**RE: Existing Tank Application # BRES2005-0051**  
**122 Fifty Caliber Drive Broadway, NC 27505**

An attempt was made to evaluate your property for the purpose of issuing an existing tank permit. The evaluation could not be completed for one or more of the following reasons.

PROPERTY OF STEVEN SHERMAN SR.

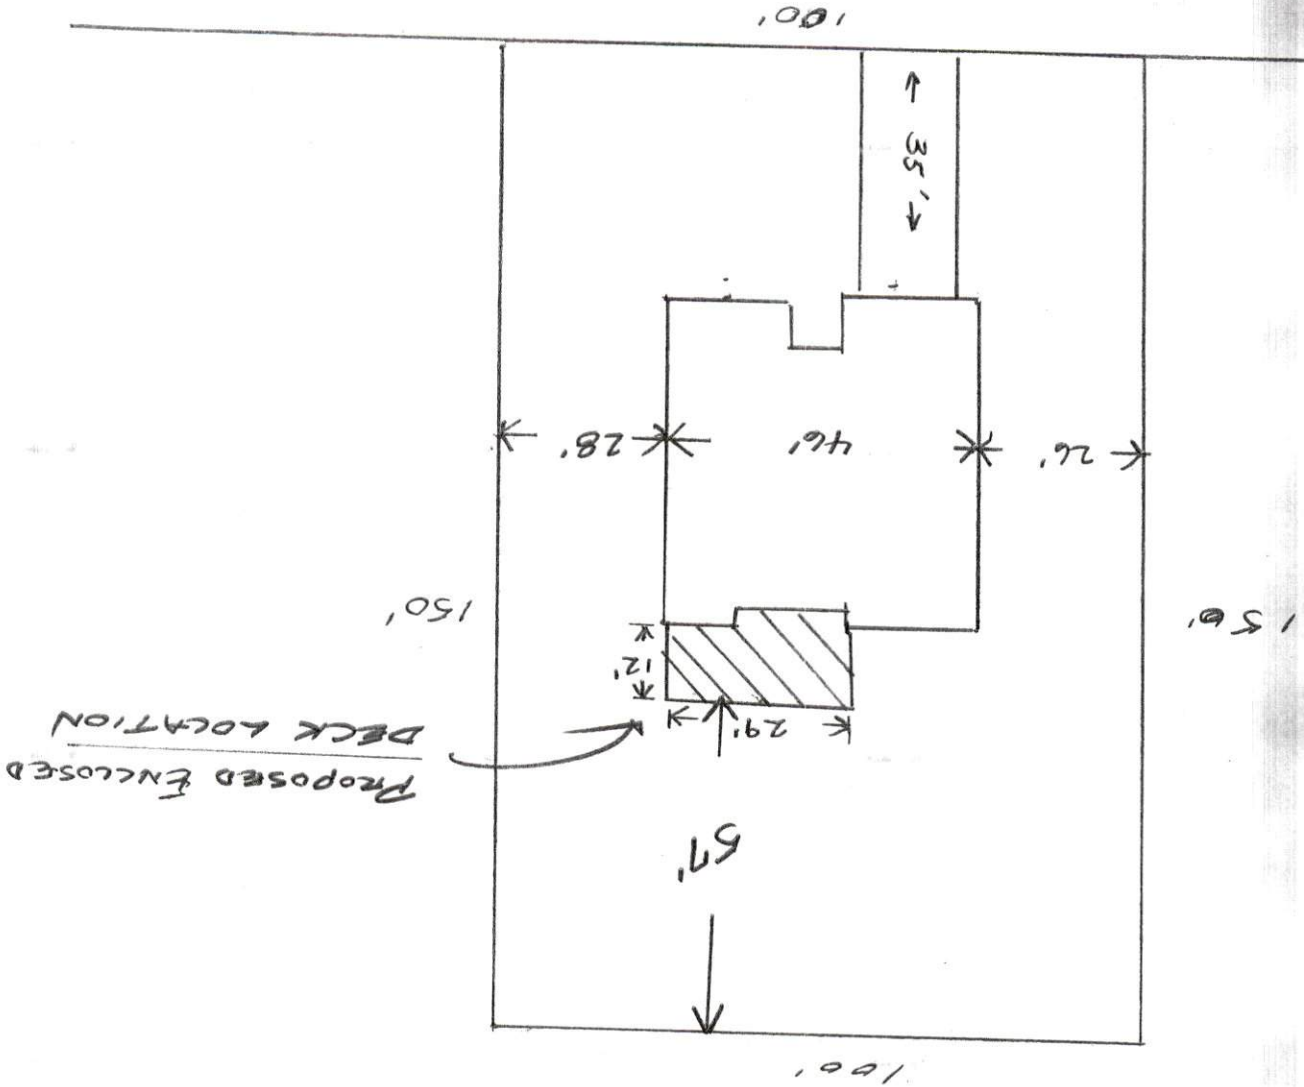
- 1. Uncover Outlet lid on septic tank and break seal. (\$25.00 fee incurred).
- 2. Have system pumped out
- 3. Replace Sanitary T
- 4. **Other – Addition does not meet septic setbacks.**
